CITY OF PORTLAND

September 23, 1999

RE: 4 Newton Street - 337-c-069 - B-1 zone

Plans for new sign

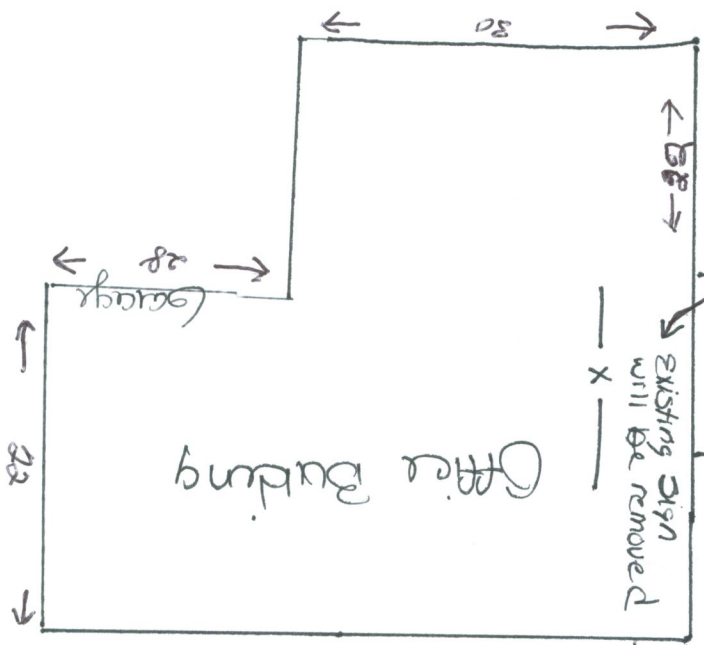
I am in receipt of your sign application at 4 Newton Street. Your permit application is being denied as proposed. Off-premise signs are not allowed in the City of Portland. Your application shows advertising for another business use at a different location. This is not allowed.

If you wish to redesign your sign for your business on the premises, I will be glad to do a second review of your proposal. Please also note that since this is a corner lot, there are special height provisions for signs. Any sign located in a triangular area created by extending 25 feet in both directions from the point of the corner (at curb line), a sign shall be no taller than 3.5 feet in height. Your sign permit shows that this sign will be 5 feet in height. You need to revise your plans to either move your sign or to lower it to meet the provisions of the ordinance.

Again, your permit cannot be issued as submitted. Your permit will be on hold for not more than 60 days if we do not receive a revised plan from you in the mean time.
